Sheringham Shoal and Dudgeon Offshore Wind Farm Extension Projects

Explanatory Note to Updated Offshore Works Plans

January 2023
Document Reference: 2.7.1
APFP Regulation:

Title:	
Sheringham Shoal and Dudgeon Offshore Wind Farm Extension Projects Examination submission	
Explanatory Note to Updated Offshore Works Plans	
PINS document no.: 2.7.1	
Document no.: C282-EQ-Z-GA-00023	
Revision: A	
Date:	Classification
5 January 2023	Final
Prepared by:	
Equinor	
Approved by:	Date:
Sarah Chandler, Equinor	5 January 2023

Sheet 2

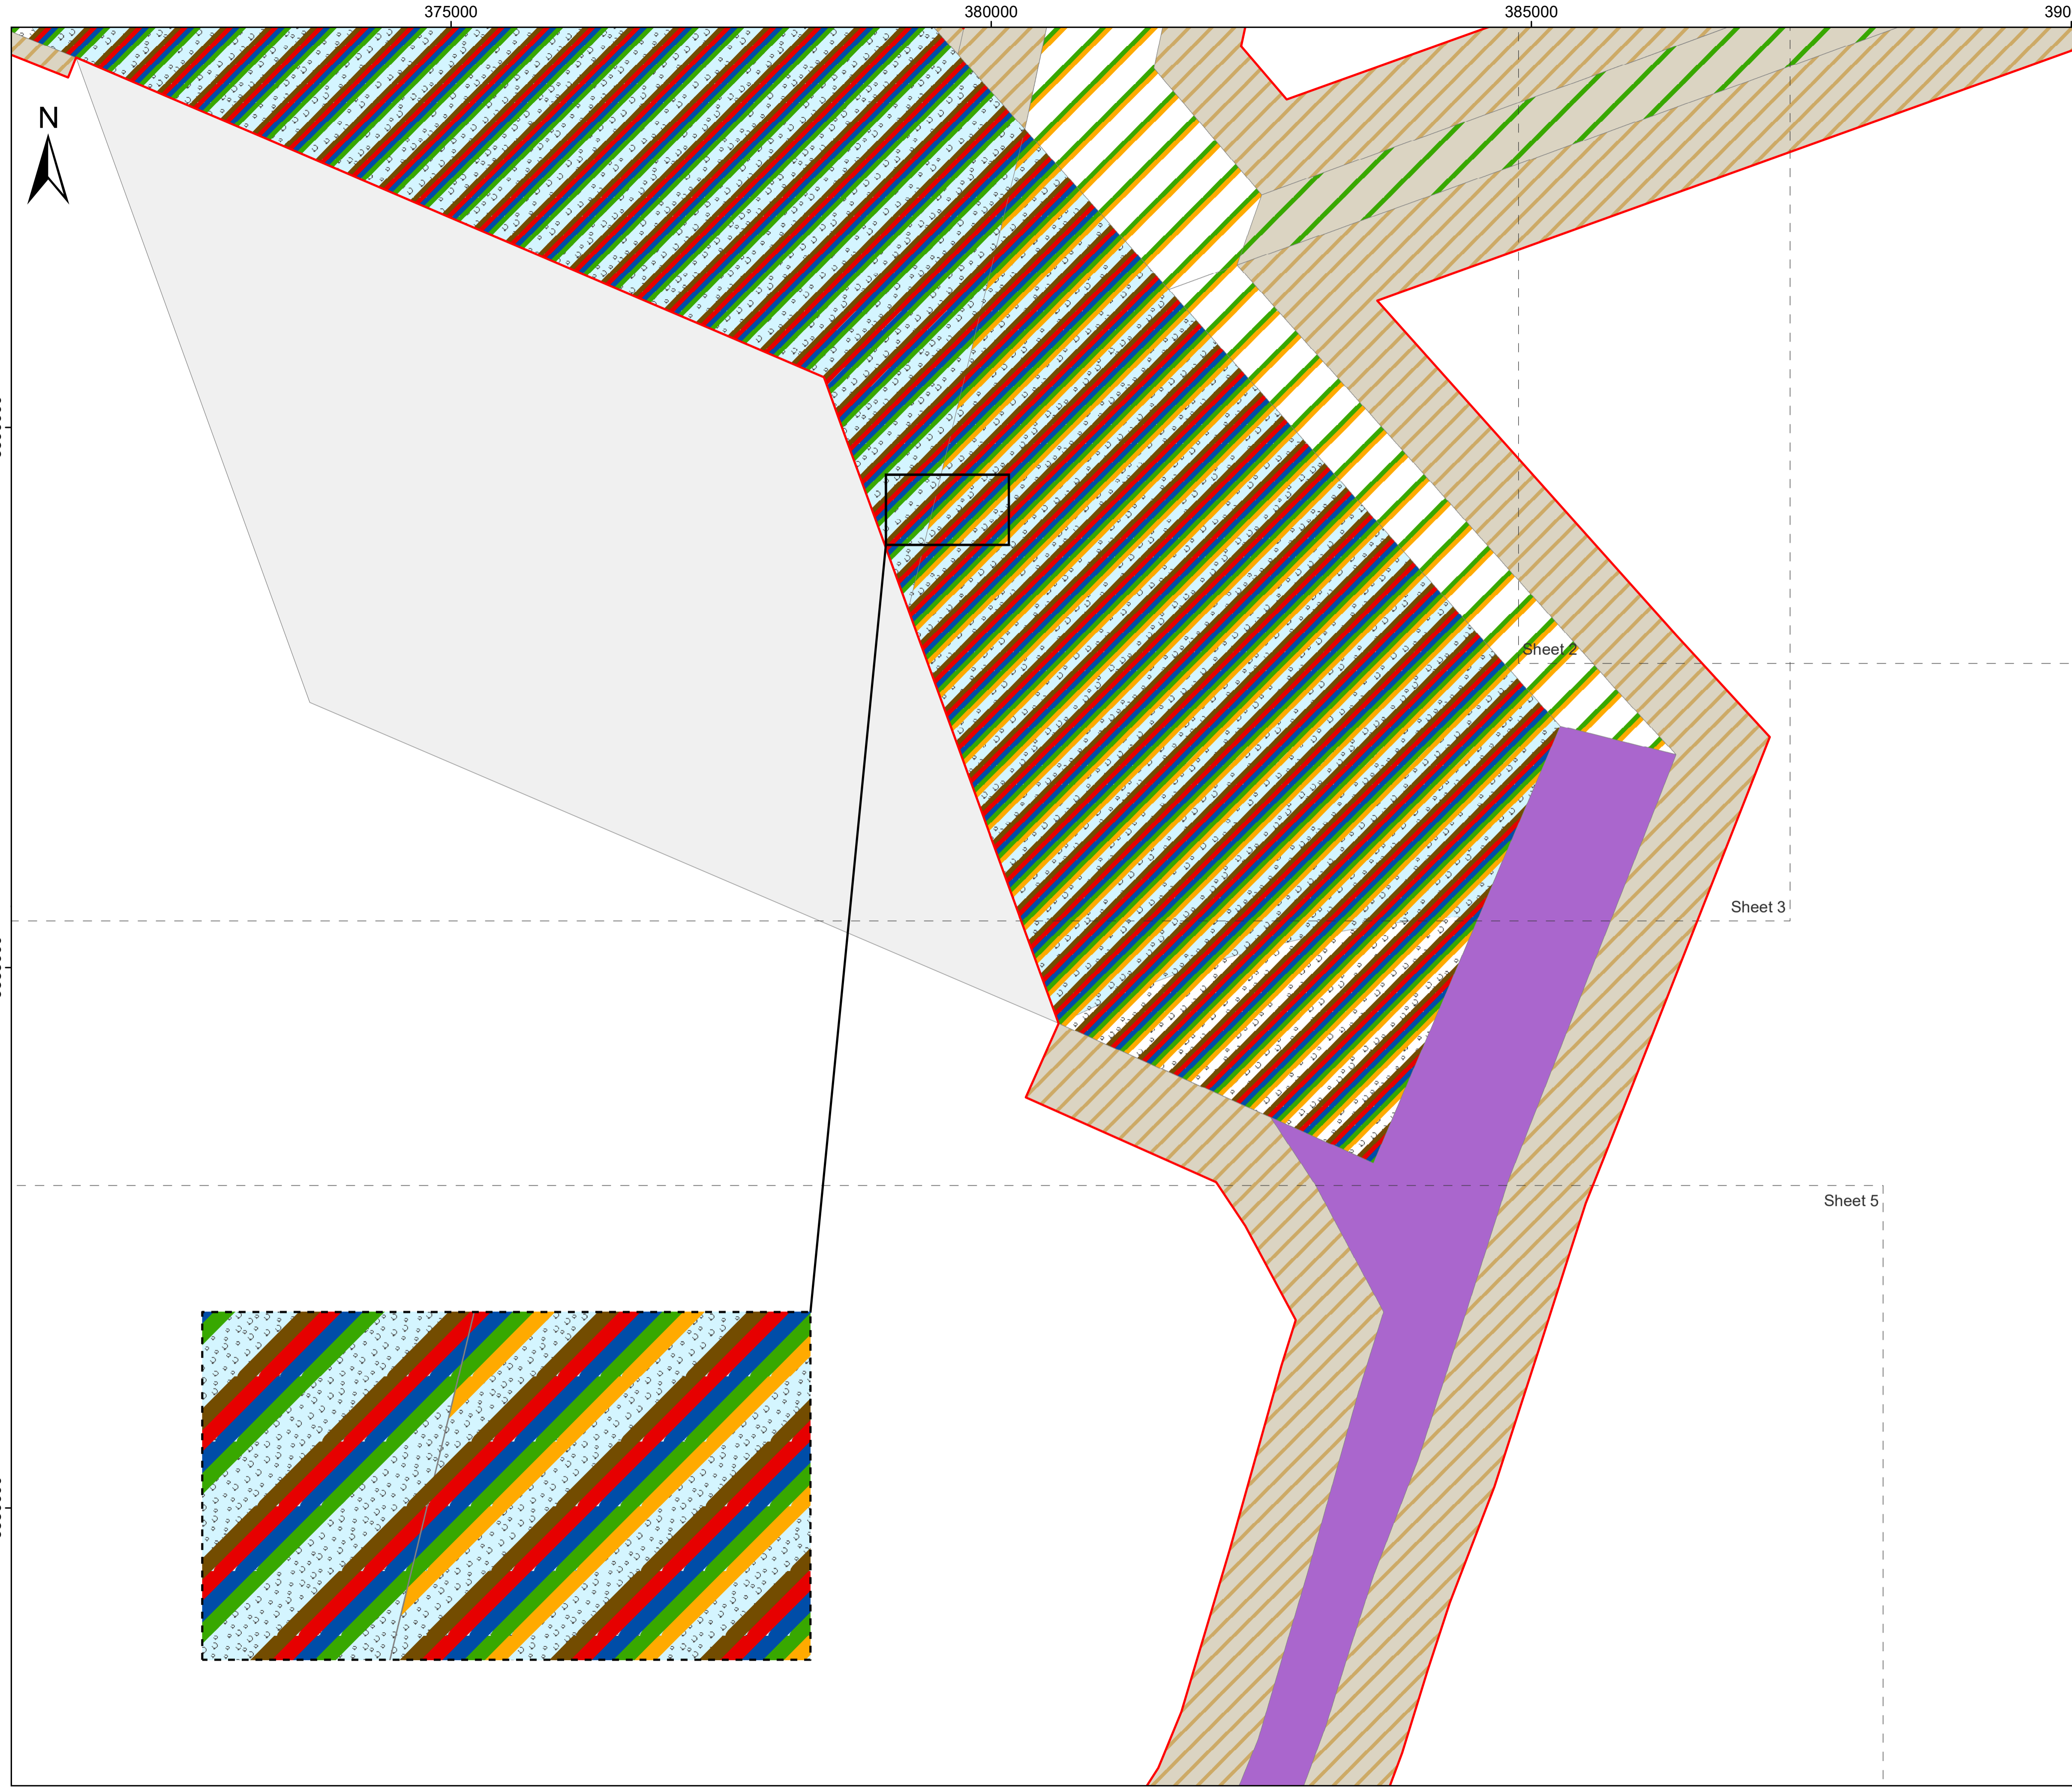
- Work No. 4B and 4C (export and interlink cables) have been included in the DEP North and DEP South array areas, where previously they were limited to the cable corridors only.

- The presentation of Work No. 6C (temporary working area) on the scenario 4 plans has been changed to be consistent with that used on the "all scenarios" plans.
